**Consultation Response from Mike Hibbert,
KC Waste Strategy(Refuse & Recycling)**

2024/92281 Land adj, 17, Whitehall Road West, Birkenshaw, BD11 2LS

Erection of 23 dwellings

Responding Ref: WPN 24-035

CLIENT:	ORION HOMES		
PROJECT:	LAND ADJACENT TO 17 WHITEHALL ROAD WEST		
TITLE:	SWEEP PATH ANALYSIS REFUSE VEHICLE ACCESS (ENTERING)		
SCALE @ A3:	NTS	APPROVED:	DATE:
		DRS	27/06/2024
PROJECT No:	2024376	DRAWING No:	REV:
		DPL SK006	A
© Development Planning Limited

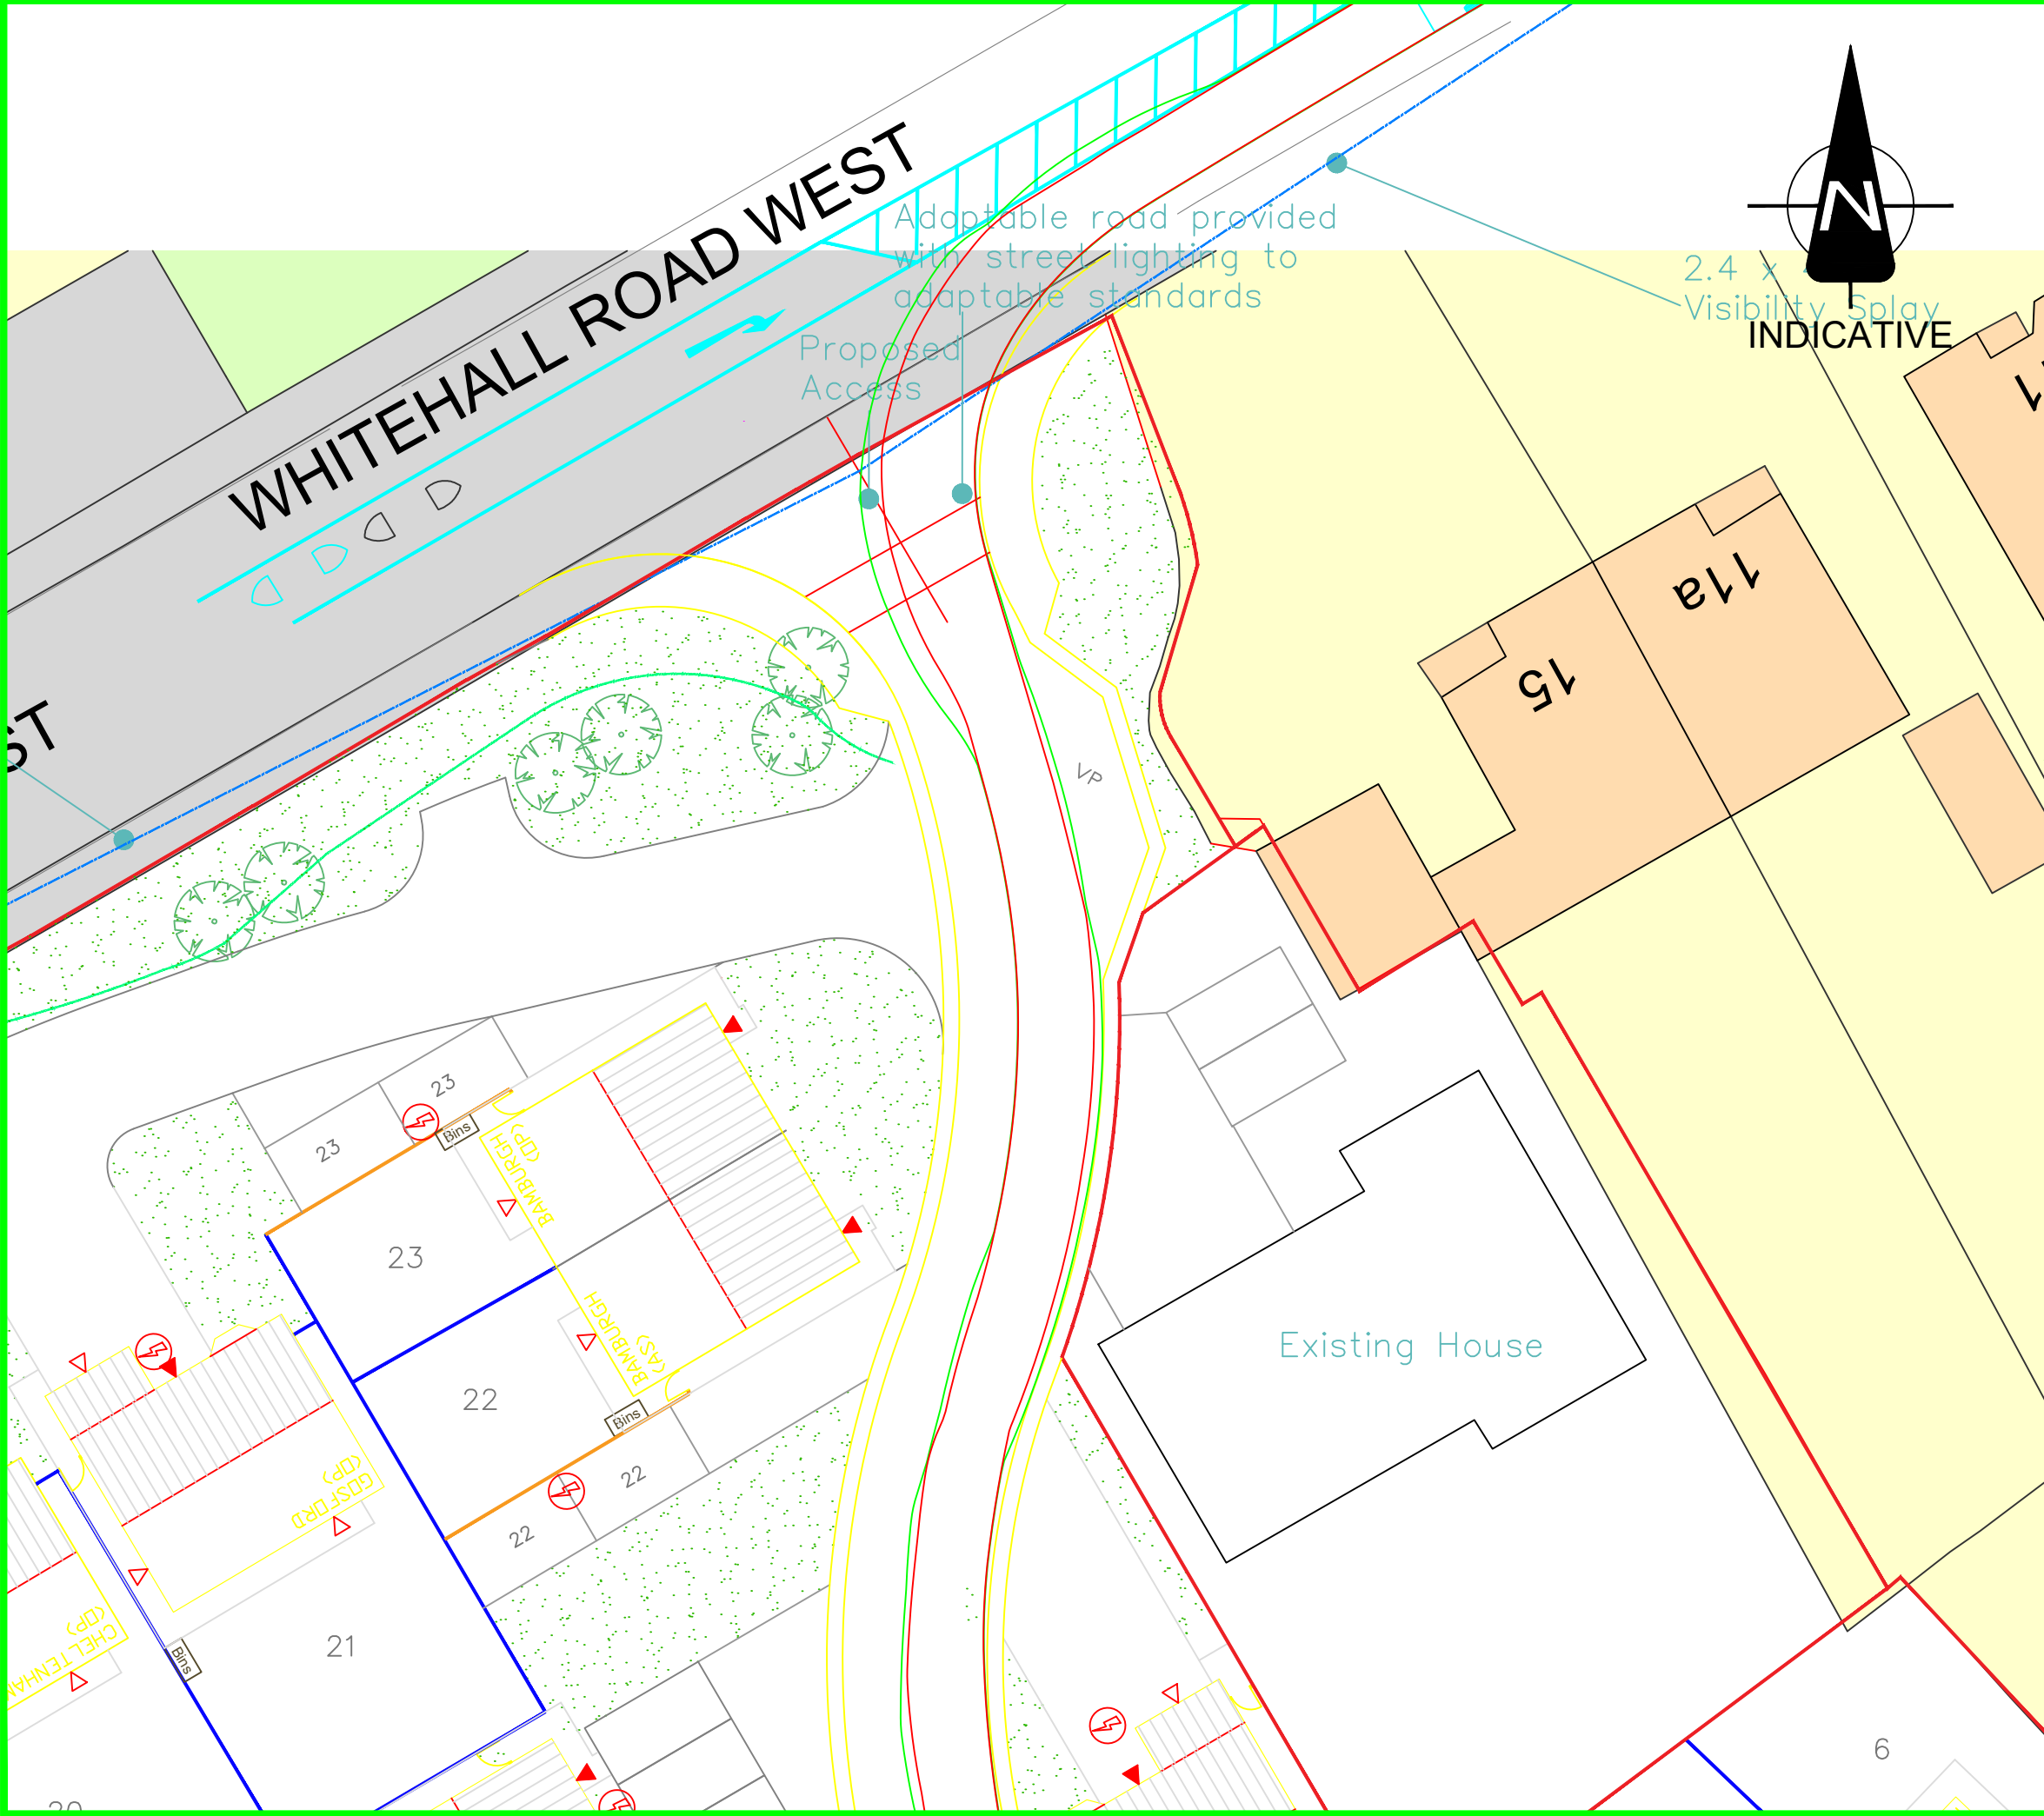
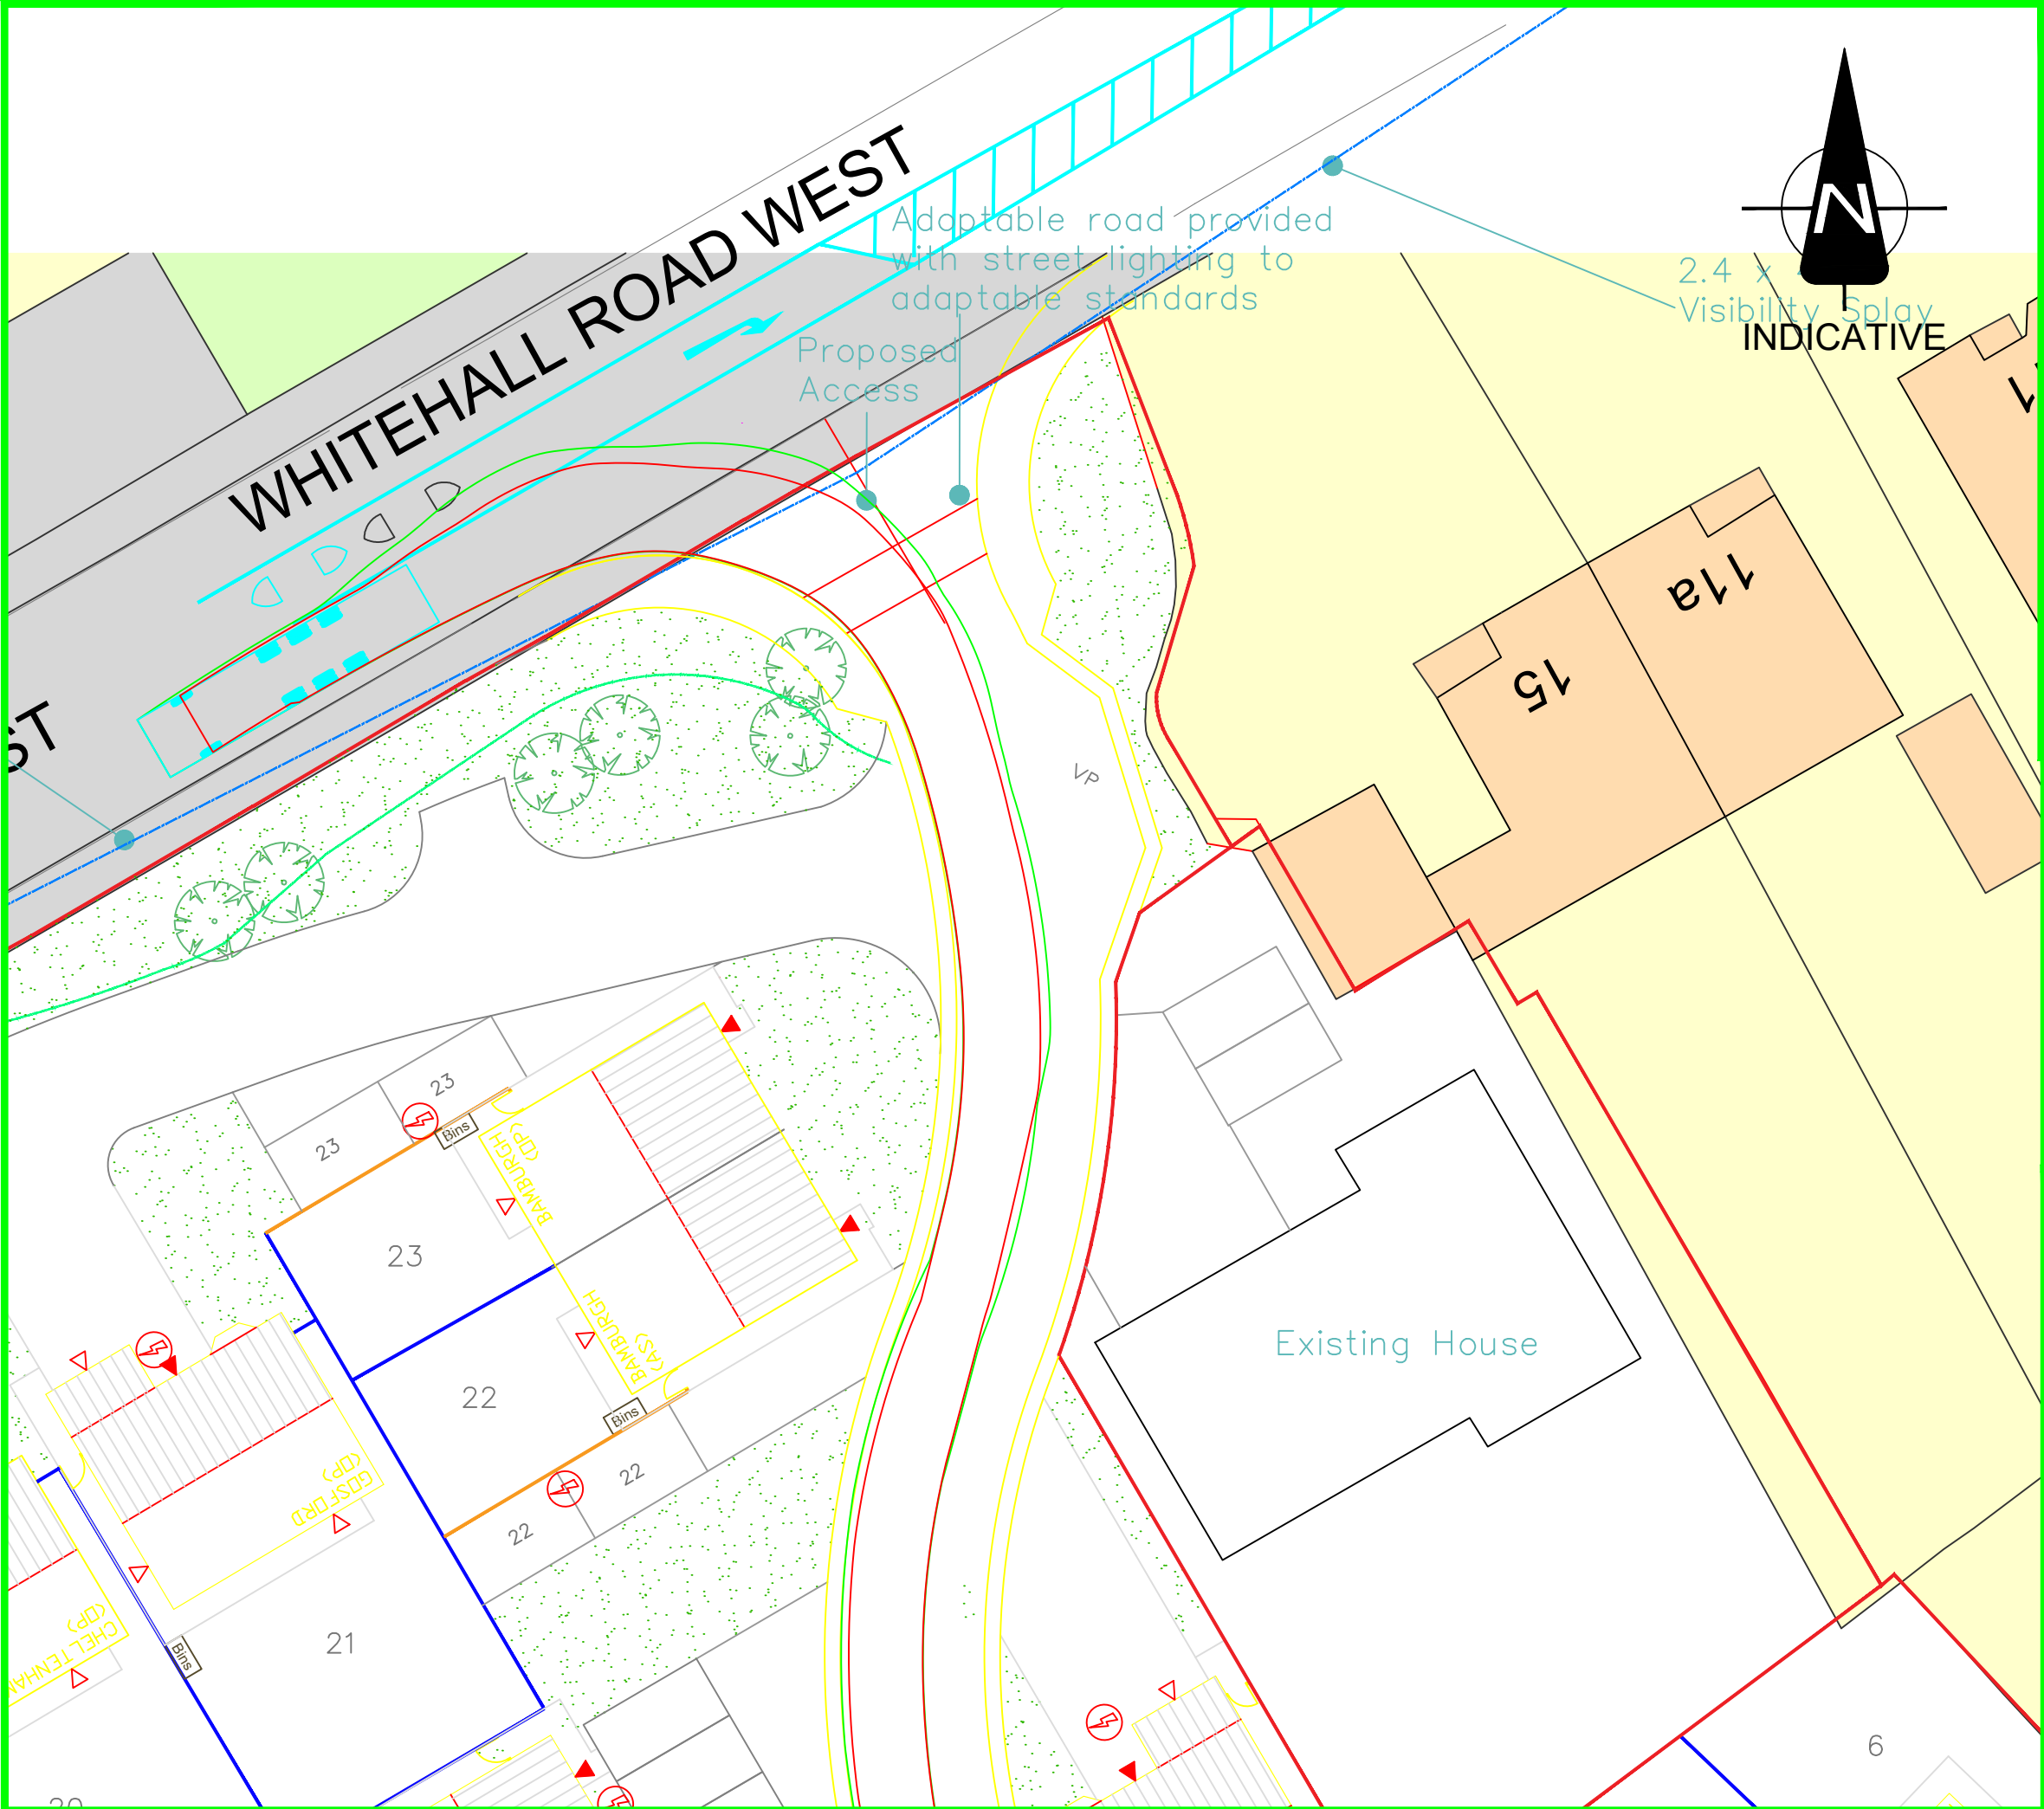
- Swept path analysis must show the manoeuvrability of this vehicle throughout the site, demonstrating the safe passing of other vehicles likely to be using the road – either parked or moving.

- Parked cars are a perpetual problem for RCV access and as such it is important to account for potential parking spaces, even where these are undefined when assessing RCV access around the site.

- The turning head between Plots 9 and 12 must be demonstrably sufficient for an 11.22m refuse collection vehicle. **Active measures should be taken to prevent parking in the turning head as otherwise an RCV would have a long reverse manoeuvre, that is a recognised safety risk and is not acceptable.**
